Changes to an Application by Highways England for an Order Granting Development Consent for the A1 in Northumberland – Morpeth to Ellingham

Thank you for offering Natural England the opportunity to comment on the above. The comments given below relate solely to **Change 2: Stabilisation Works** (Change Request – 6.38 Environmental Statement Addendum: Stabilisation Works – Rev 1) and **Change 3: Southern Access Works** (Change Request – 6.40 Environmental Statement Addendum: Southern Access Works – Rev 1). Natural England does not have any comments to make regarding **Change 1: Earthworks Amendment**.

Figure 3 - Geomorphological Map of the Area around the Proposed Site

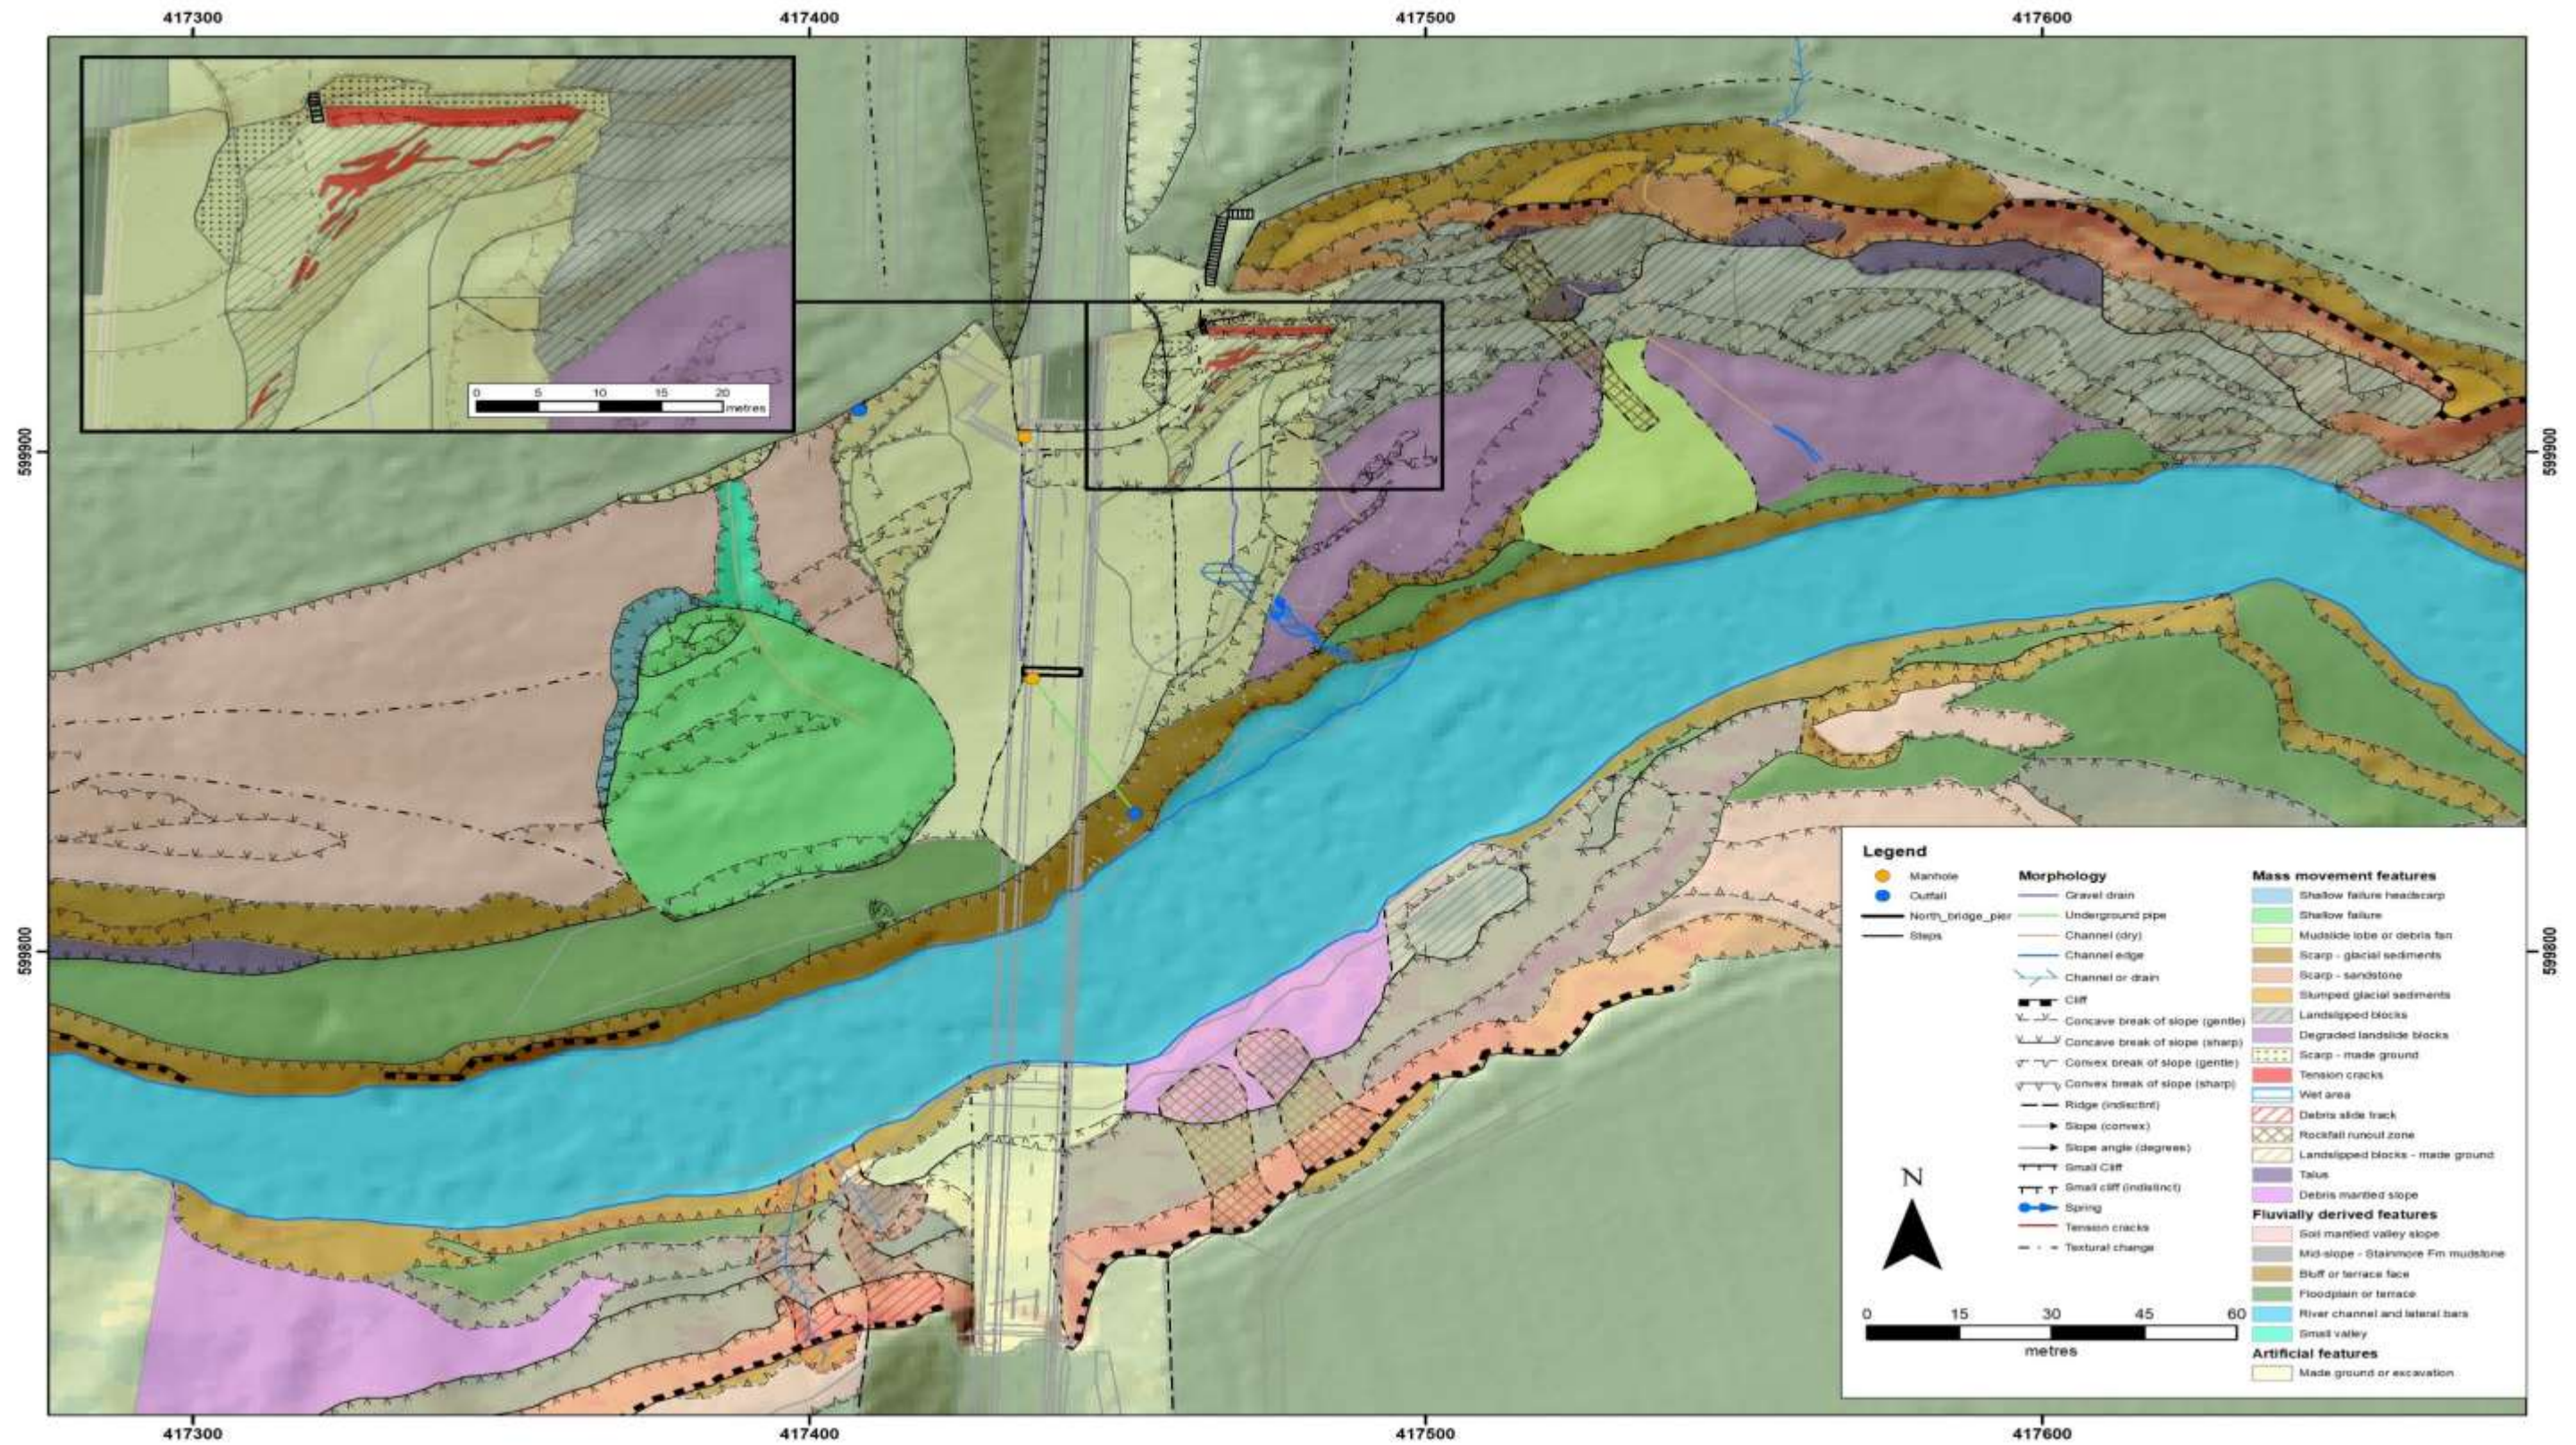
Natural England does not agree that the permanent loss of natural riverbank which will disconnect the terrestrial habitat from fluvial process constitutes a minor adverse impact. The scour protection when combined with the slope stabilisation works will permanently cut of the supply of sediment from the northern bank. The applicant's surveys show slumping due to a slip fault which would suggesting that, over a long

time period, this area has probably been an important source of sediment for the river. Periodic events, such as slope failure, add significant amounts of material to the river and drive change with the river adapting and evolving in response to the changes on the adjacent terrestrial habitat, which if left in its current state, would continue to act as a natural sediment source into the future.

Natural Fluvial process will be prevented by the scour protection and the channel would no longer be able to adjust and evolve over time. When the scour protection on the northern bank is view in combination with that proposed for the southern bank, this section of river is effectively going to be permanently canalised under the new and existing bridge structures. The proposal will impact on how the channel evolves over an area larger than the actual footprint of the proposed work and this will lead to a longer -term deterioration of the channel and its flora and fauna. The long-term consequences of this has not been assessed.
